**RE: Peter & Liz Heredia Residence
Lot 22 Block 6 Unit 22 SAD 228
8009 Camino Alto Ct NW
Grading and Drainage Plan
Engineers Stamp Date 9/7/16 (D10D003B22)**

Based upon the information provided in your submittal received 8/26/16, the above referenced Grading and Drainage Report and plan cannot be approved for Grading Permit or Building Permit until the following comments are addressed:

ENGINEER'S SEAL 8/25/16 DAVID SOULE P.E. #14522	LOT 22 BLOCK 6 UNIT 22 VOLCANO CLIFFS SUBDIVISION	DRAWN BY JDG
	GRADING AND DRAINAGE PLAN	DATE 08-25-2016
 Rio Grande Engineering 1606 CENTRAL AVENUE SE SUITE 201 ALBUQUERQUE, NM 87106 (505) 872-0999	SHEET #	1 OF 1
	JOB #

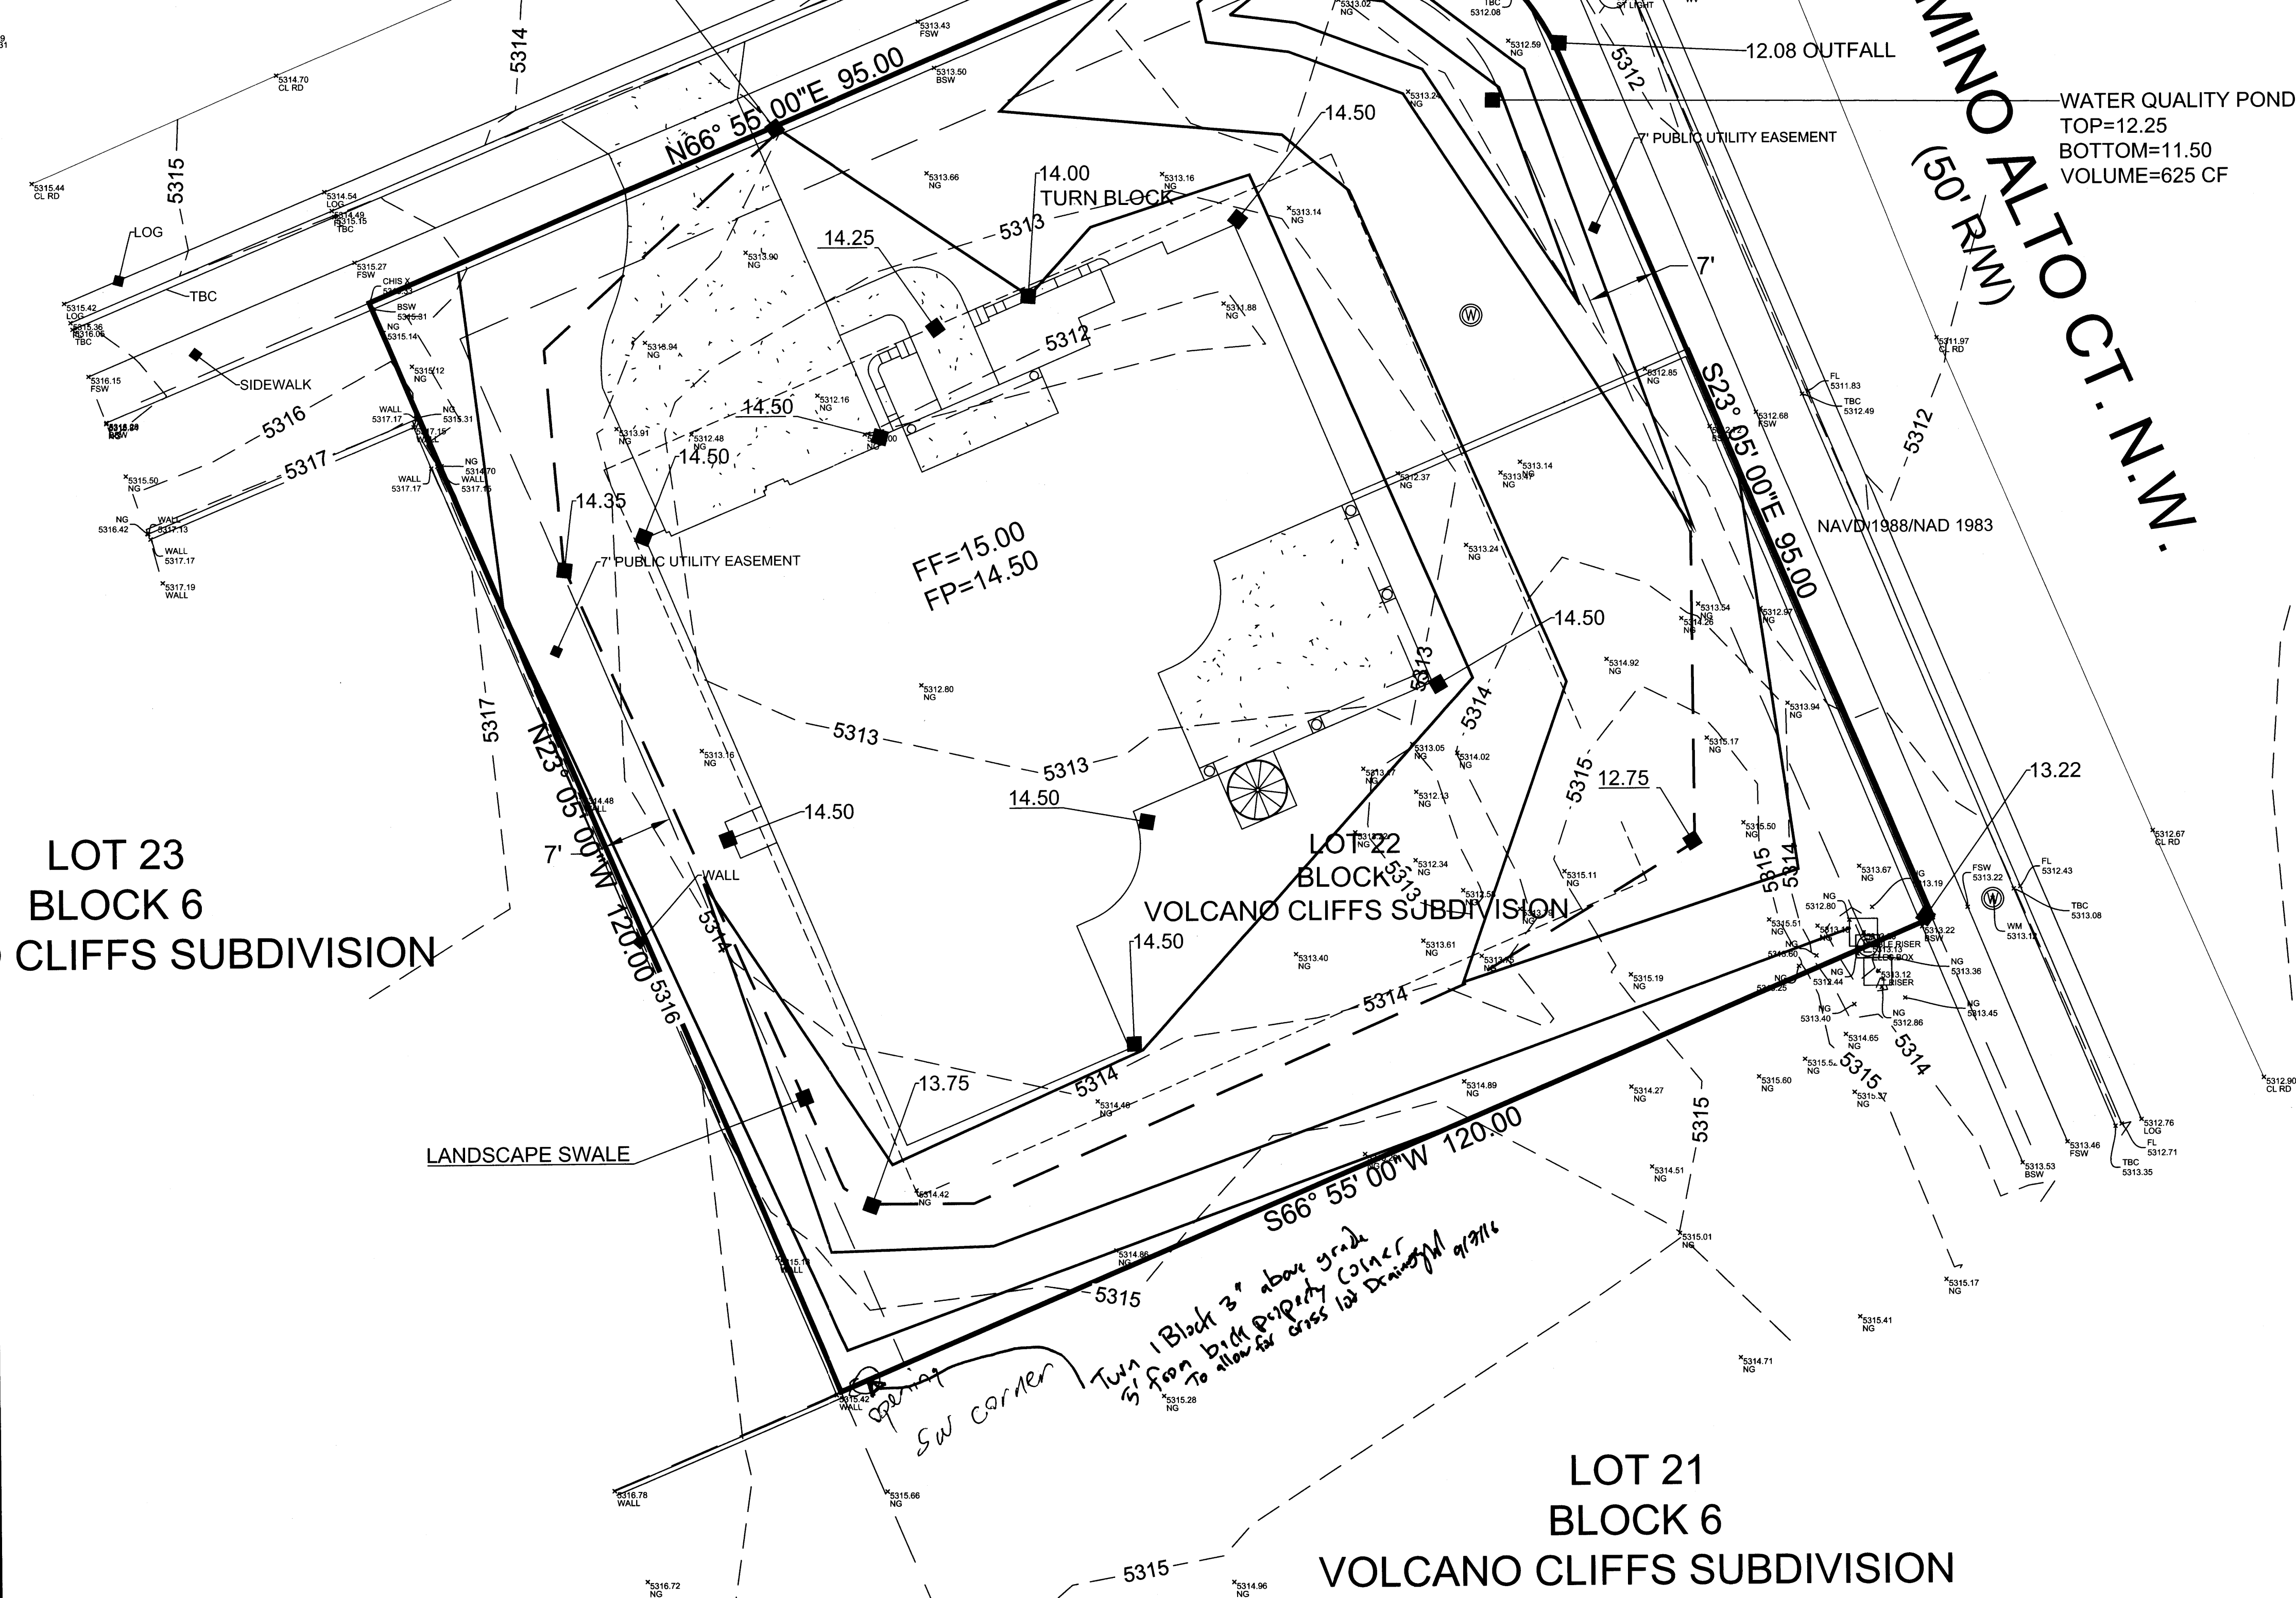
1. Provide a statement in the SW corner of the plan about an opening in a wall which is required for flows to enter from the south property.
2. Correct the city address on the DTIS, it shows 6308 Papagayo NW.
